Application H09-0867-19
Location Land off: Balmoral Way Holbeach Spalding
Proposal Details of Conditions 3, 4, 5, 6, 7, 8, 9, 10, 11, 13, 14, 15 and 16 of H09-0706-19)

Name Sue Armour
Address Environmental Protection Officer SHDC PE11 2XE

Date Submitted 18-12-19
For/Against Comments

DRAWING:
Gas Membrane Details

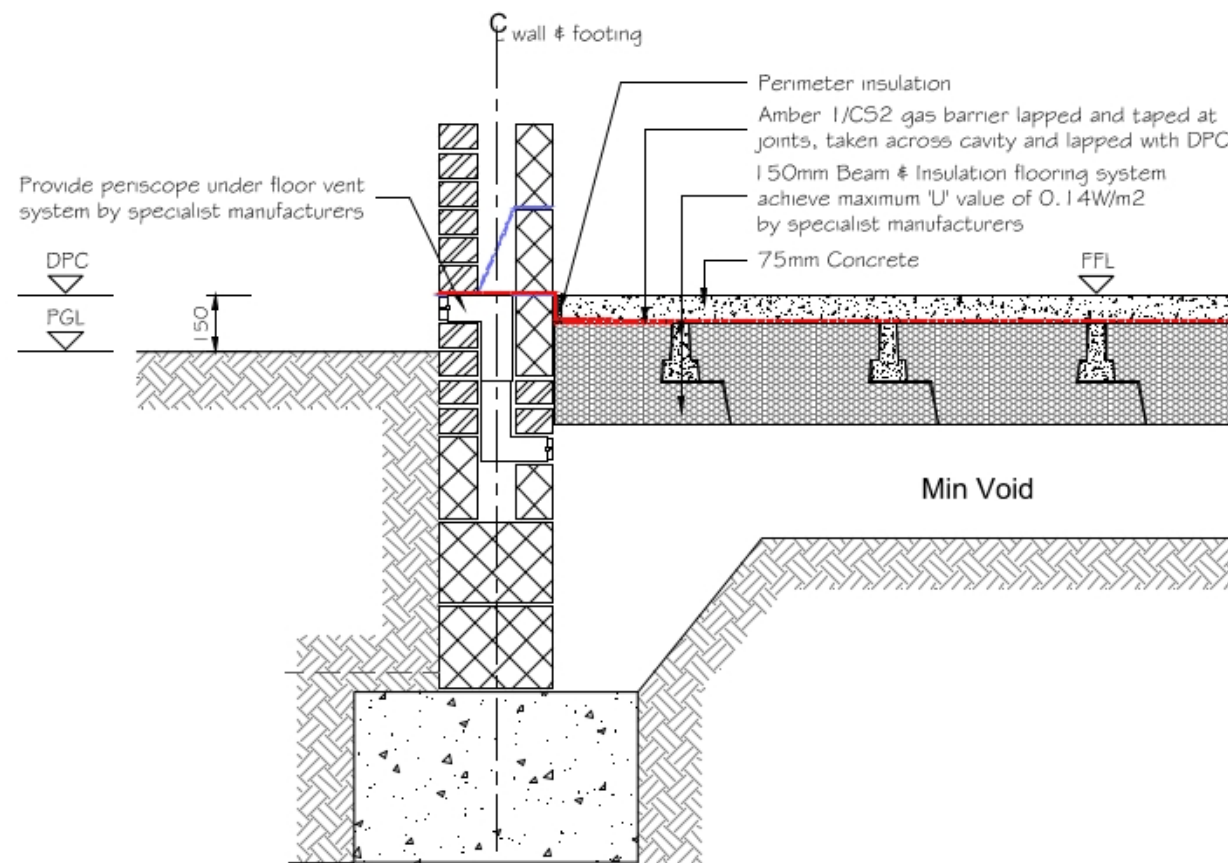
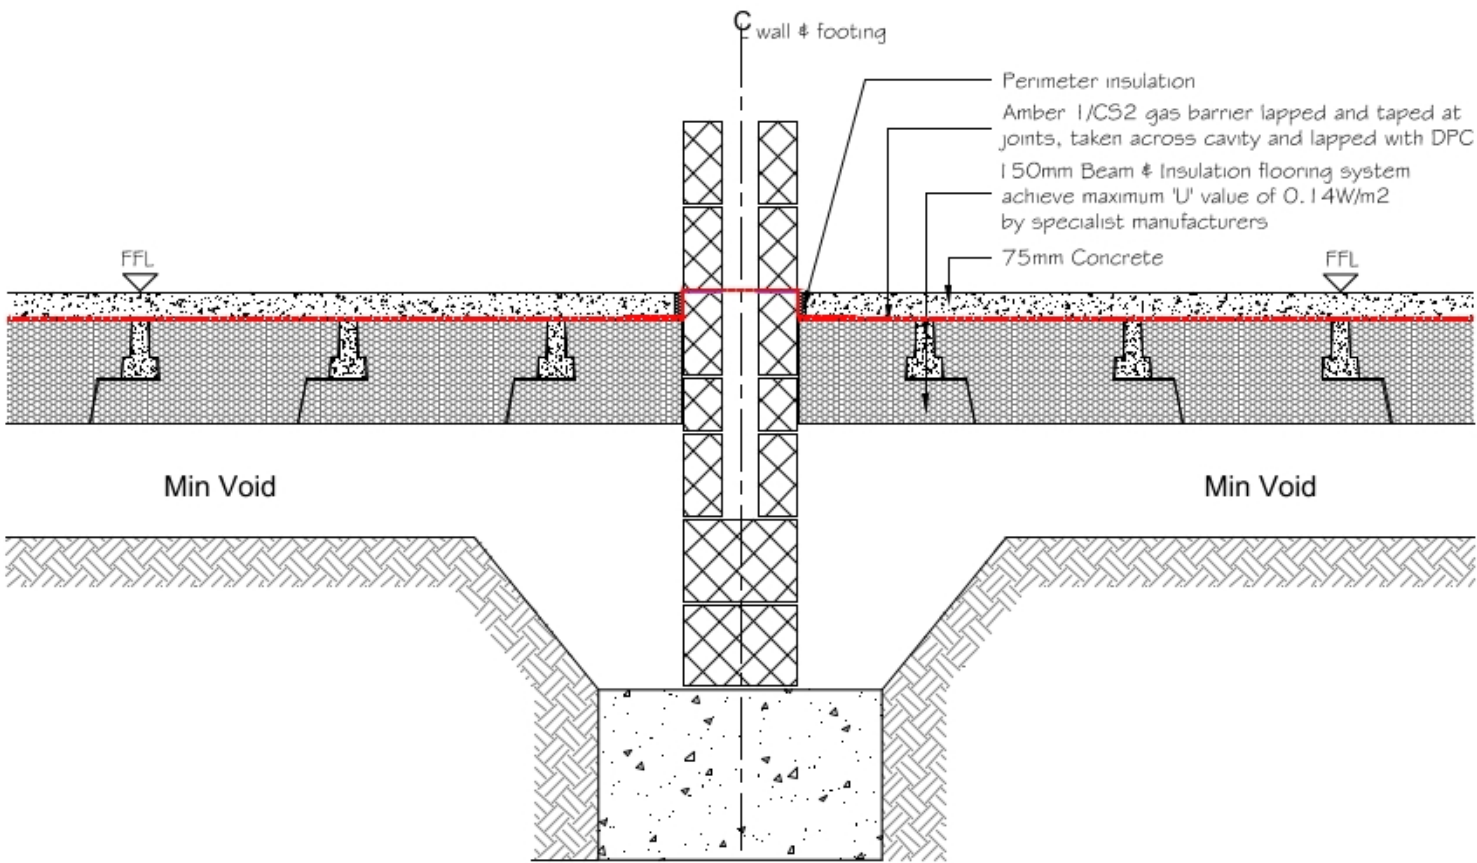
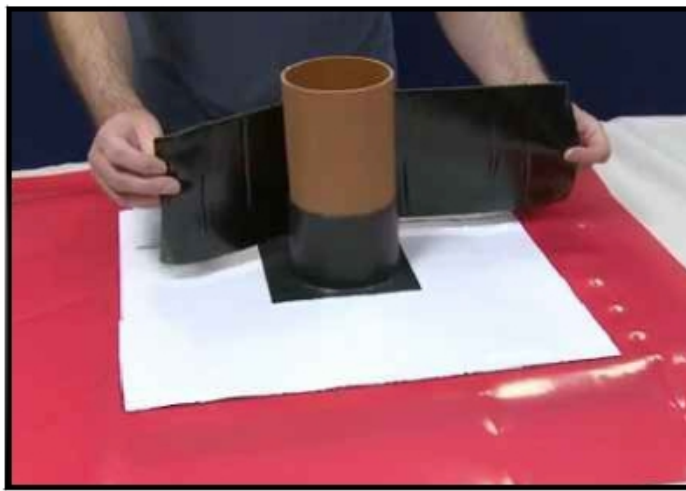
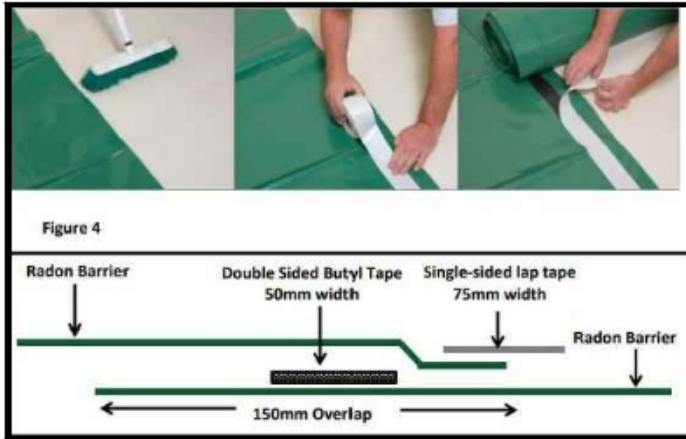
The report recommends ground gas protection measures to CS2. A remediation strategy including the proposals for the ground gas protection measures to be installed and the proposed validation should be submitted to this department as soon as possible, as I note that works have started on site. I strongly suggest that they do not progress any further until this is agreed.
